MEMORANDUM

DATE:	February 12, 2021	RWDI REFERENCE #: 1904405
TO:	Anthony Witherdin	Director, Key Sites Assessments - DPIE
FROM:	Kevin Peddie	Email: kevin.peddie@rwdi.com
	Michael Pieterse	michael.pieterse@rwdi.com
RE:	Solar Access – City of Sydney Review Response Waterloo Metro Quarter – Building 4

City of Sydney Comments

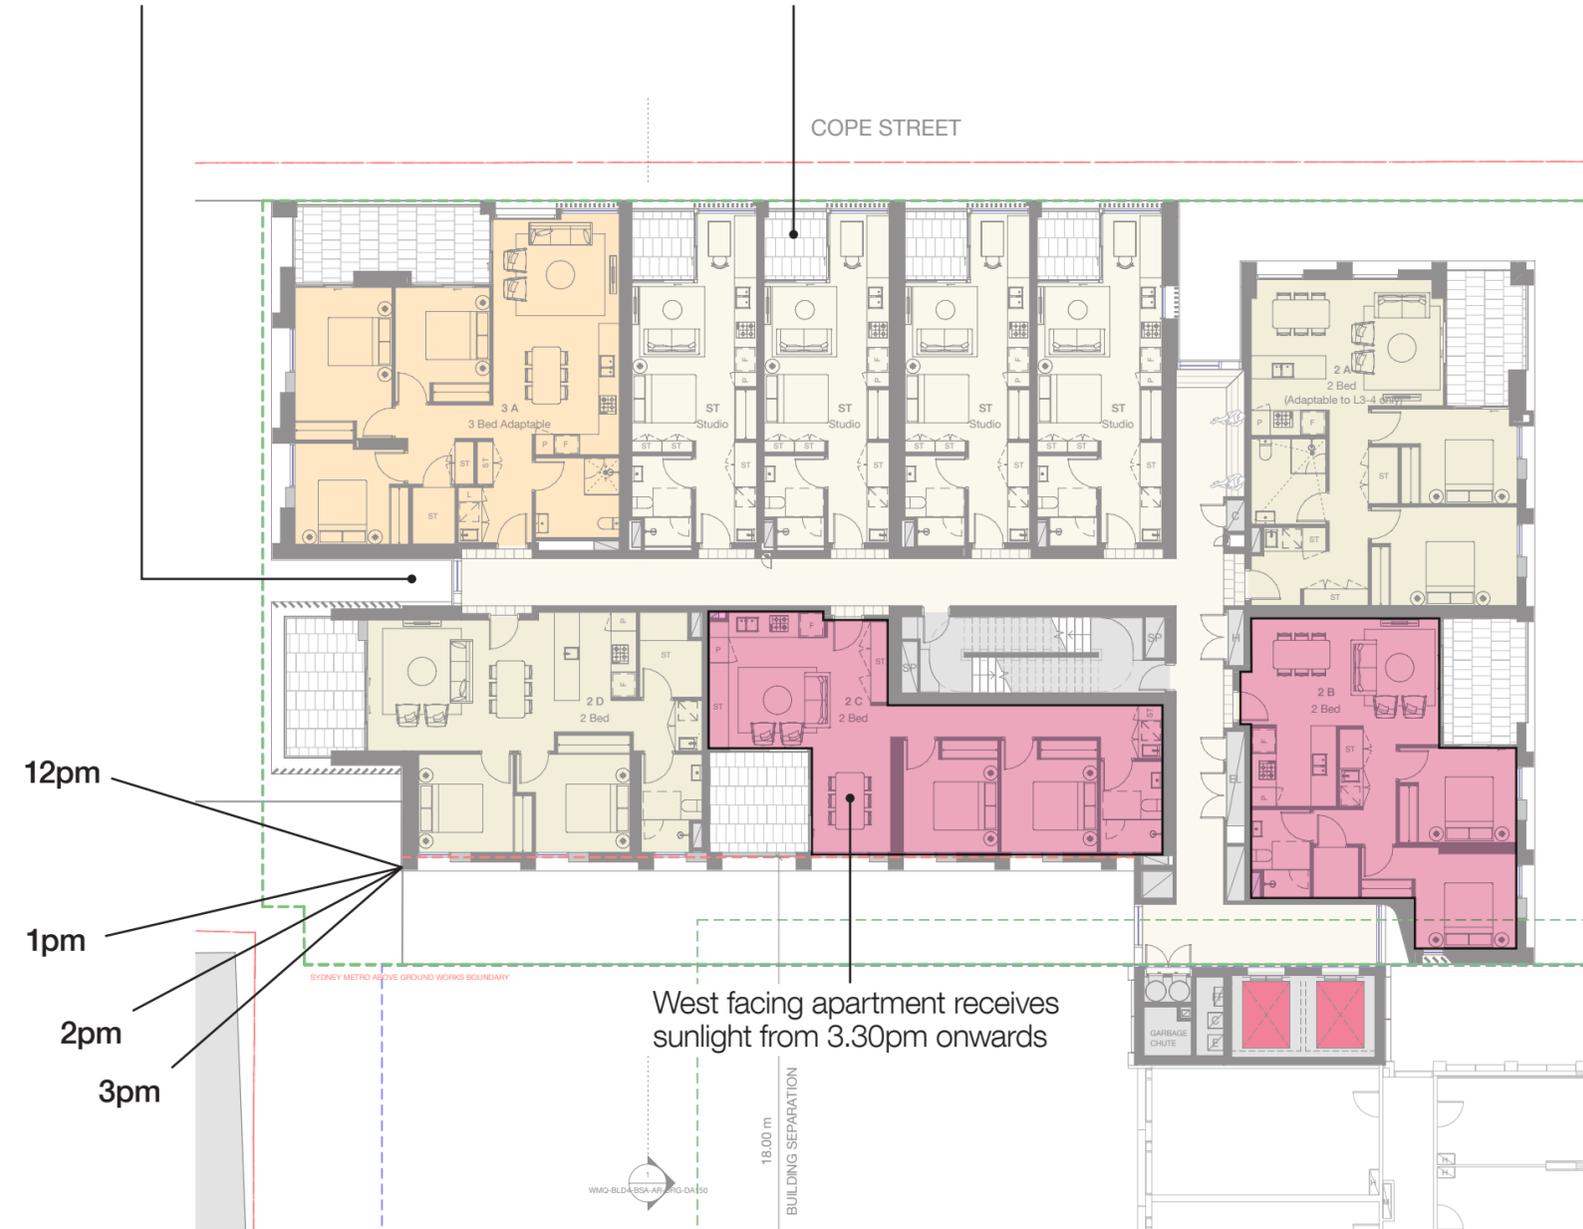
Solar access – The City notes that 15 of 70 apartments (21%) do not receive any direct solar access during mid-winter, four more than is permitted (15%) in accordance with Objective 4A-1 of the ADG. The City does not support the applicant's justification by including direct sunlight received after 3.00pm as this is not reflected in the design guidance or criteria and is of little thermal benefit due to the low altitude of the sun. Furthermore, some assertions regarding solar access are overstated, for example the quality of solar access to the living room of apartment 106 (the four-bedroom apartment). The analysis ignores the fixed vertical louvres to the east facing studios on Level 2 to 7 which block winter morning sunlight to living spaces. This removes 4 apartments per floor on levels 2-7 (24 apartments) and reduces the tally to well below 70%. This issue can easily be mitigated through a condition of consent requiring the fixed vertical blades to be changed to operable vertical blades. It should be noted that the Design Integrity Report records at item 4.03 that the supported privacy solution for these apartments is a "sliding privacy and sunscreen". This has now been removed from the scheme and further endorsement should be sought from the Panel.

The Solar Access study was undertaken by RWDI for the residential apartments associated with Building 4 of the development. Section 8 – Assessment and Findings, of the reports outlined the results of the modelling, noting the number of apartments which will have access to direct sunlight on June 21 between 9:00am and 3:00pm. The results provided an initial summary of the number of apartments which satisfied both direct sunlight to the living space as well as the private outdoor area, as well as a breakdown of each component. The assessment for the number of apartments which do not receive access to direct sunlight between 9:00am and 3:00pm for at least 15minutes is also detailed below.

Number of Apartments	Assessment Scenarios
73% (51 out of 70)	Apartments which receive at least 2hrs of sunlight access to the living space windows AND private outdoor areas between 9:00am and 3:00pm
21% (15 out of 70)	Apartments which receive at least 2hrs of sunlight access to the living space windows
11% (8 out of 70)	Apartments which receive at least 2hrs of sunlight access to the private outdoor areas

Concern is raised with regards to the ability for the 4 eastern apartments on Levels 2 to 7 to maintain solar access due to potential shading from the vertical louvres hence note that these apartments should not be considered. As can be noted from the below image, which depicts a view from the sun at 9:15am on June 21, the sunlight is not only on the eastern façade, but also on the northern aspect of the glazing for the living space areas on these levels. Hence irrespective of the design of the vertical louvres, the living space will maintain at least 2hrs of direct solar access to the living space and private outdoor areas.
